REVISION/DEFERRED SUBMITTAL FORM

Revision Log

Permit: #2012-200

Project Address: 3310 97th Ave SE, Mercer Island, WA 98040

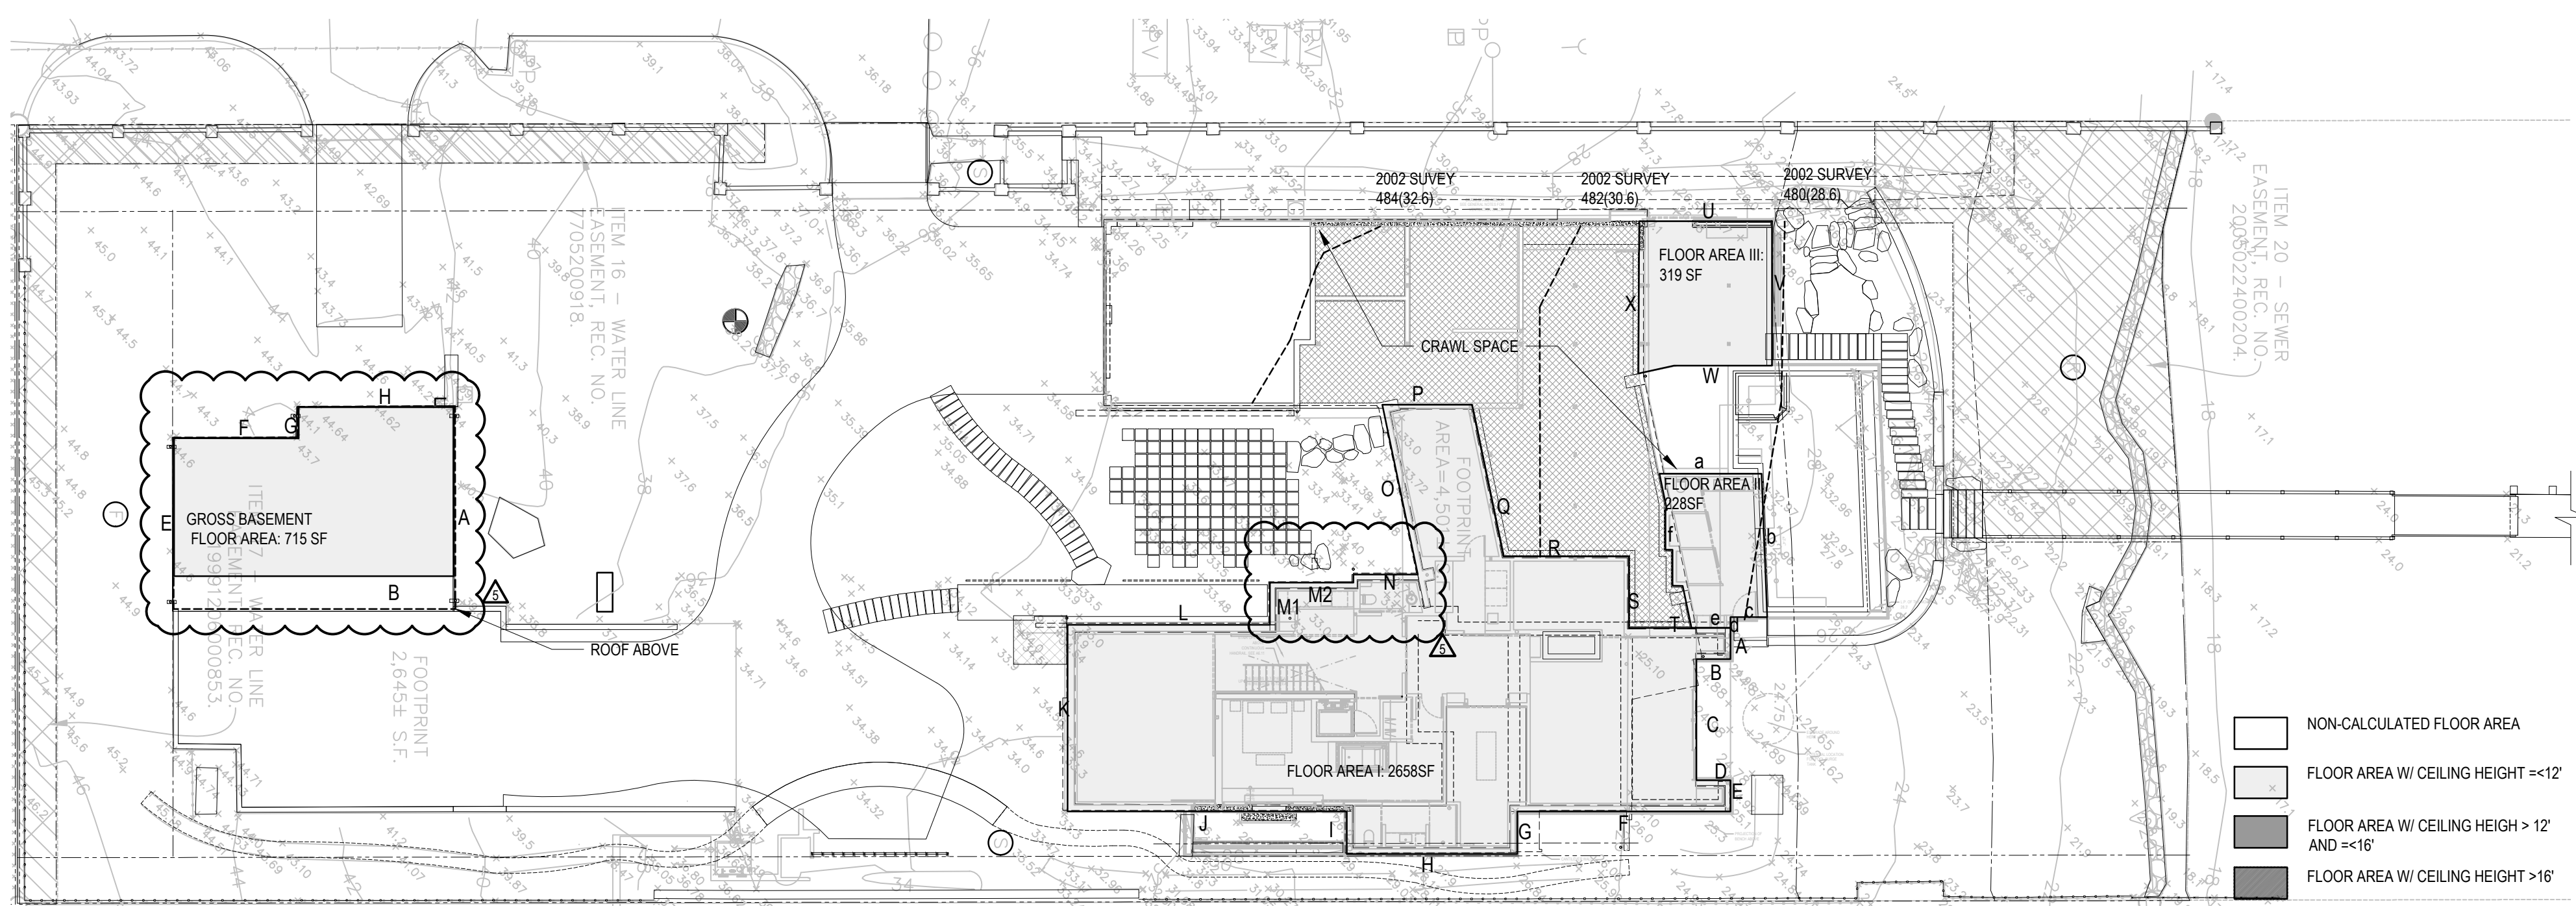
- Updated the diagrams to reflect changes for the accessory building and main building lower level
- Updated ACCESSORY BLD ABE CALCULATIONS, BASEMENT CALCULATIONS AND GFA CALCULATION

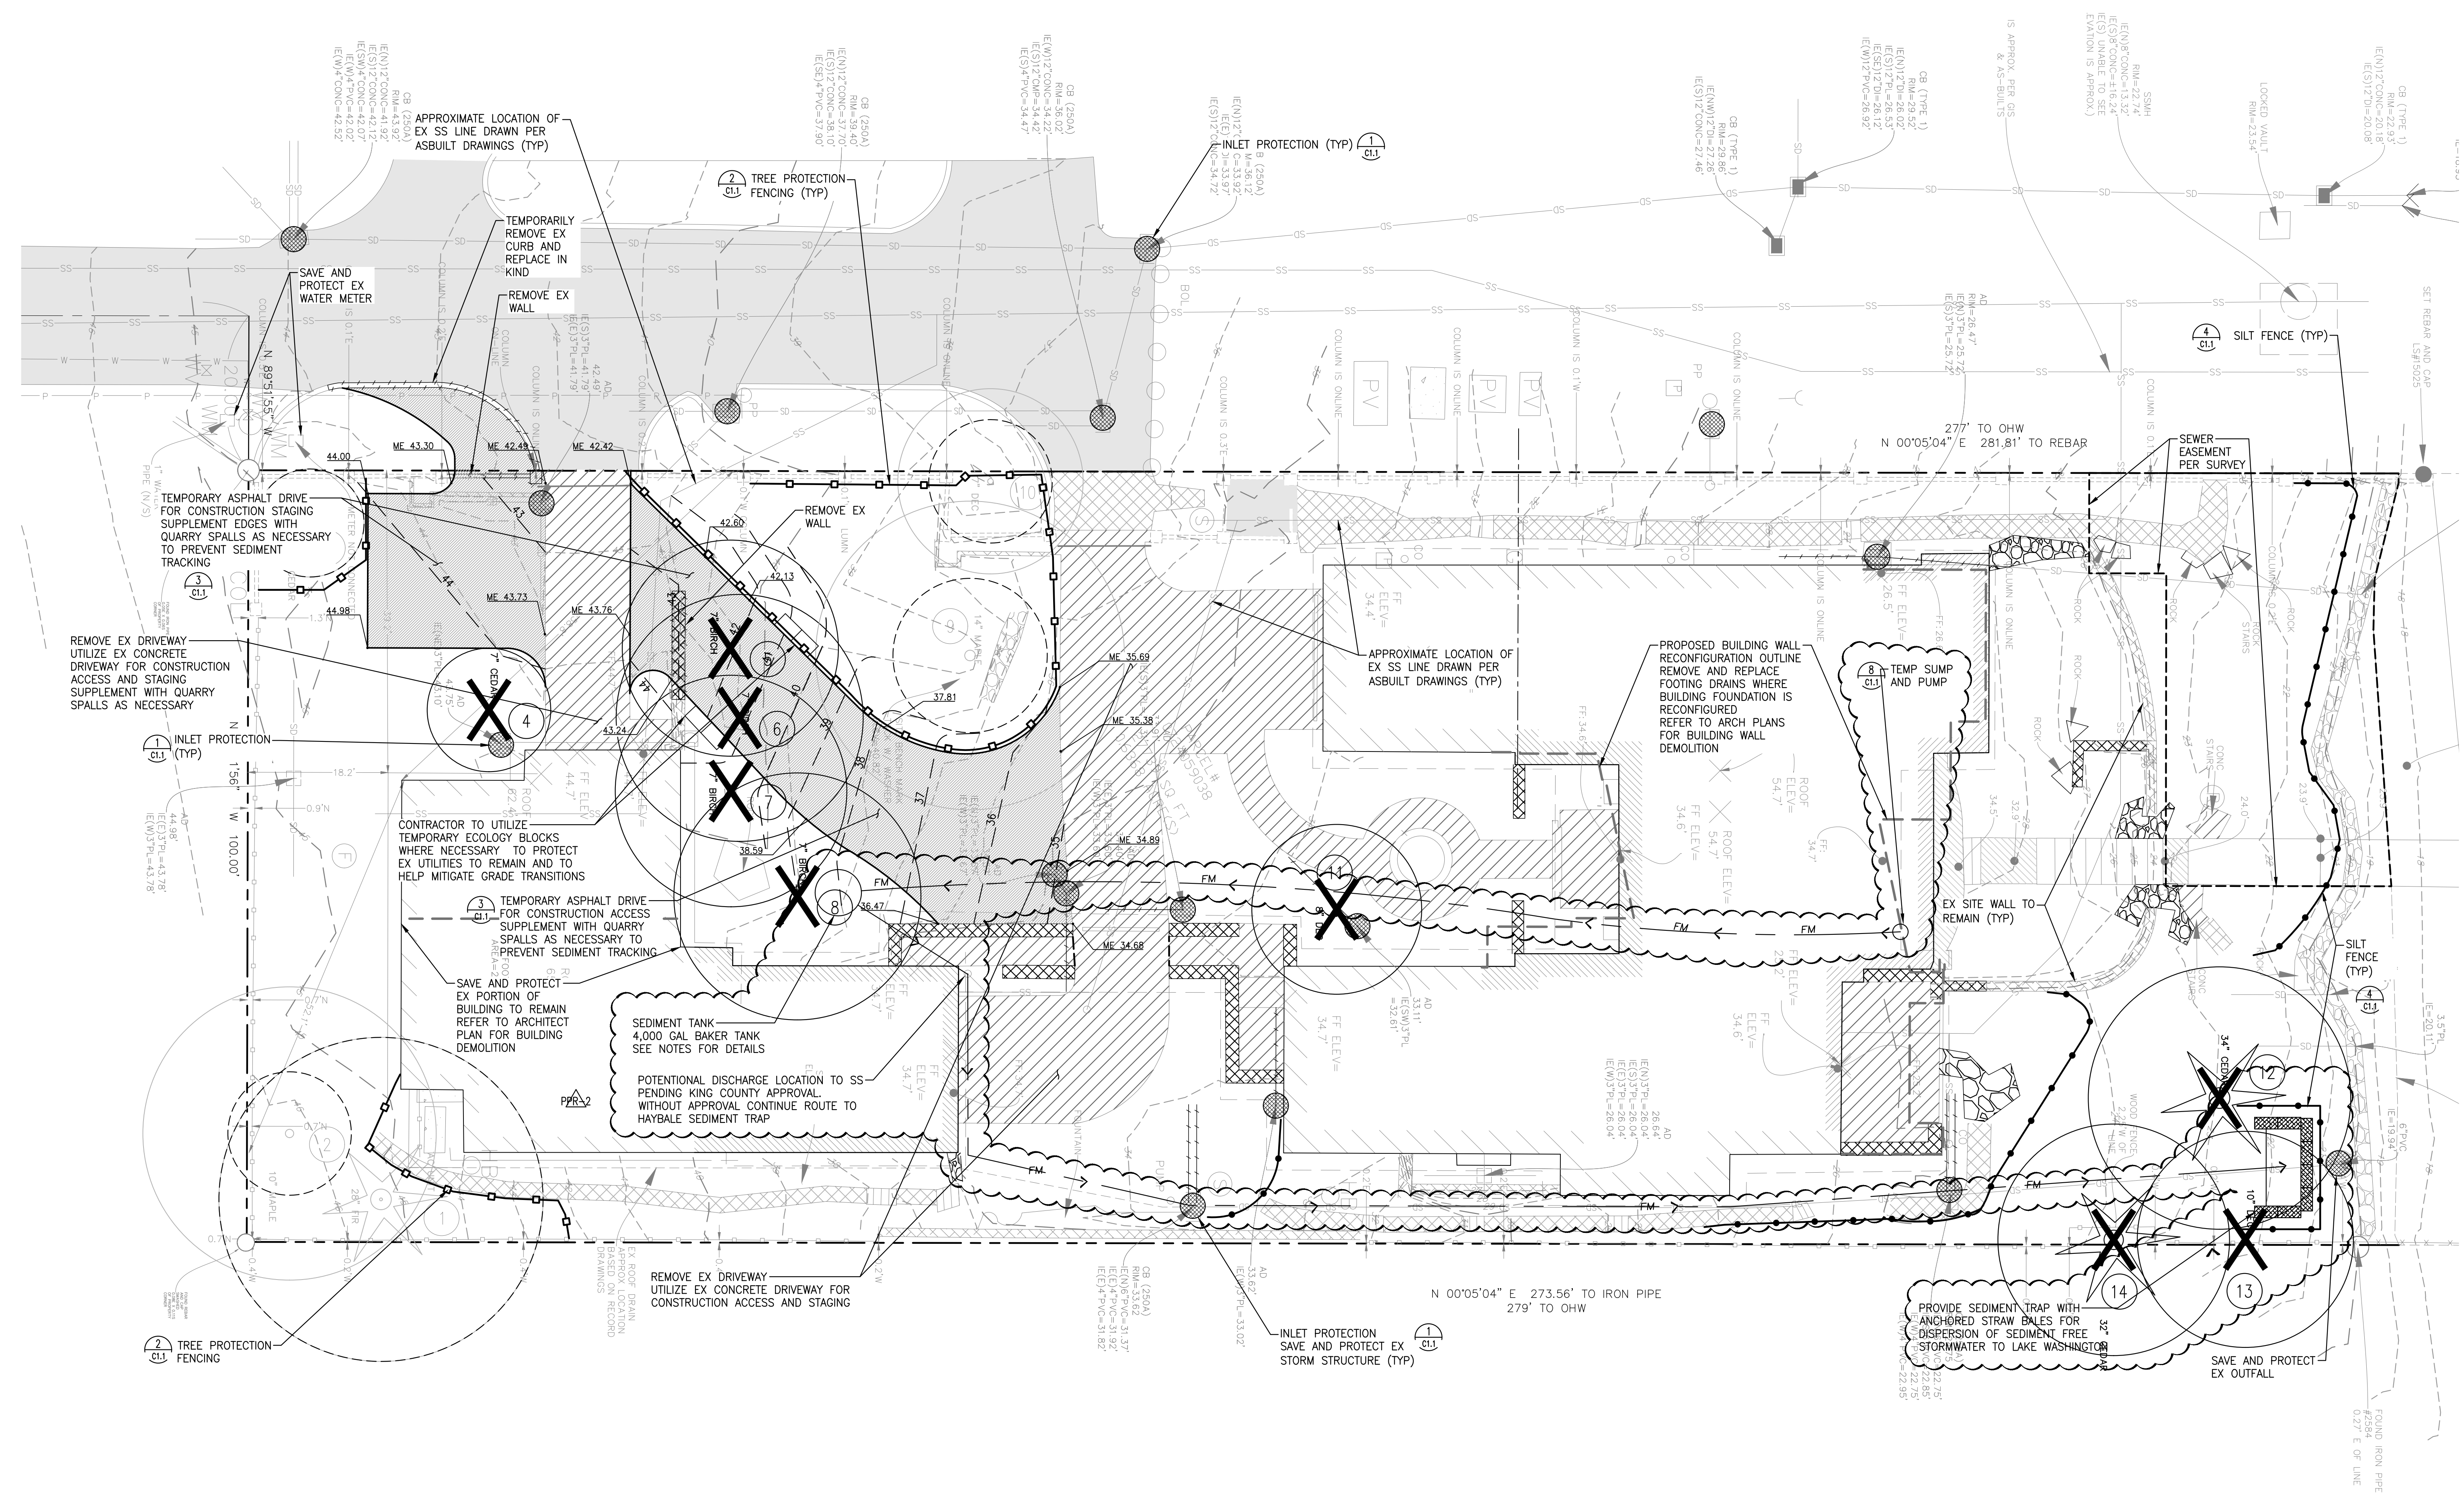
Sheet #	C1.0A	Revise location of sediment settling tank
Sheet #	C1.0A	Revise location of temporary sump and pump
Sheet #	C1.0A	Revise location of temporary force main. Provide potential routing to sanitary sewer
Sheet #		discharge point pending approval be King County.
Sheet #	C1.0A	Add hay bales and silt fence at north end of site for dispersion of sediment free
Sheet #		stormwater to Lake Washington.
Sheet #	C1.0B	Revise sheet to reflect the same revisions listed for sheet C1.0A
Sheet #	C2.0	Add additional concrete area in place of existing garage and revise grading accordingly.
Sheet #	C2.0	Add CB structure and associated piping at garage
Sheet #	C2.0	Revise downspout locations and associated piping at garage
Sheet #	C3.0	Revise sheet to reflect the same revisions listed for sheet C2.0
Sheet #		
Sheet #

SITE PLAN
A1.01

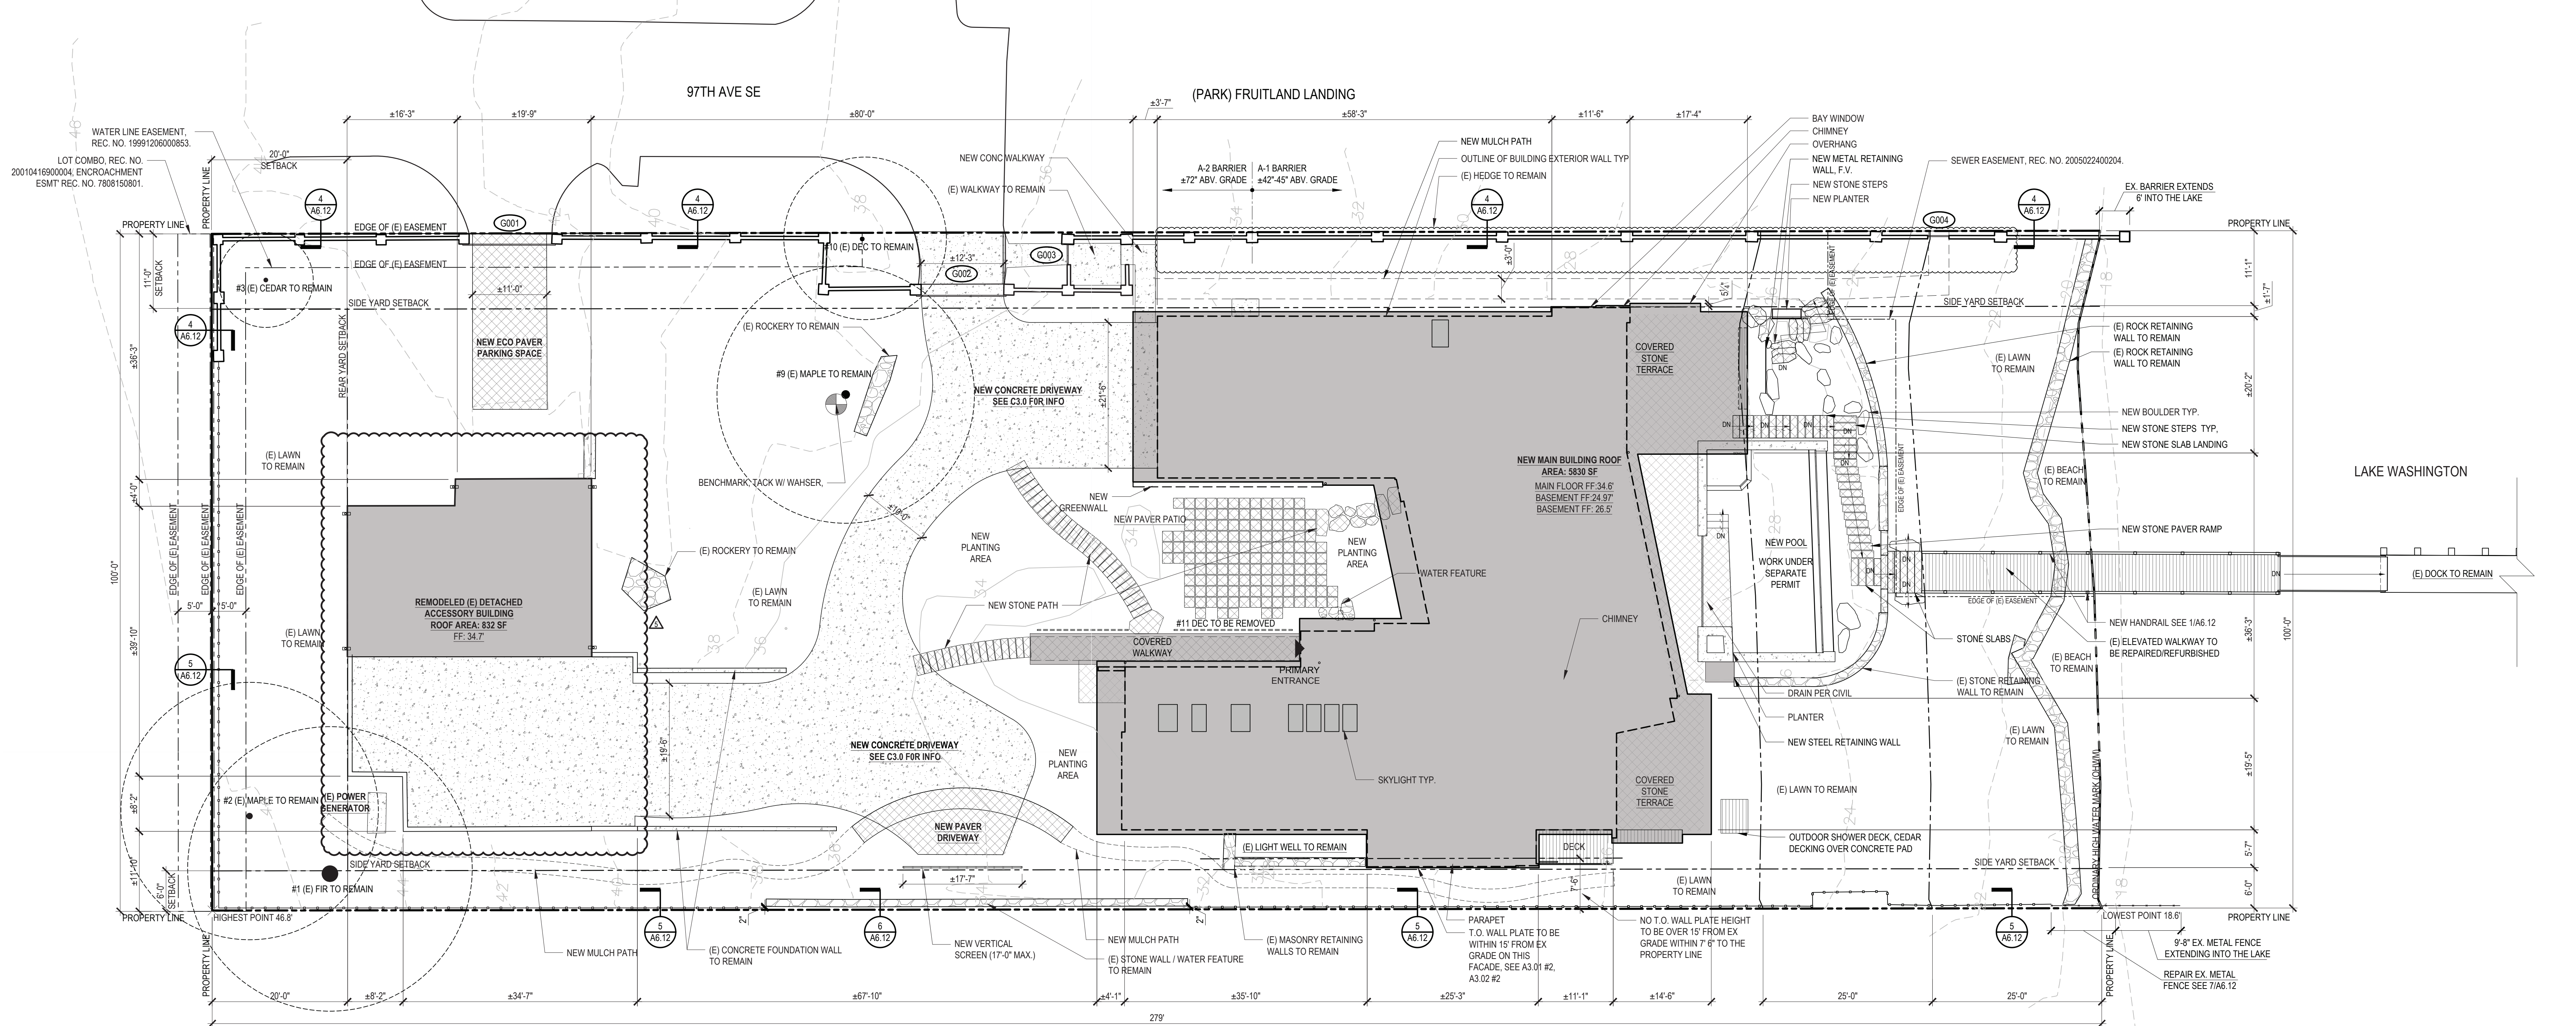
- Revised the accessory building footprint
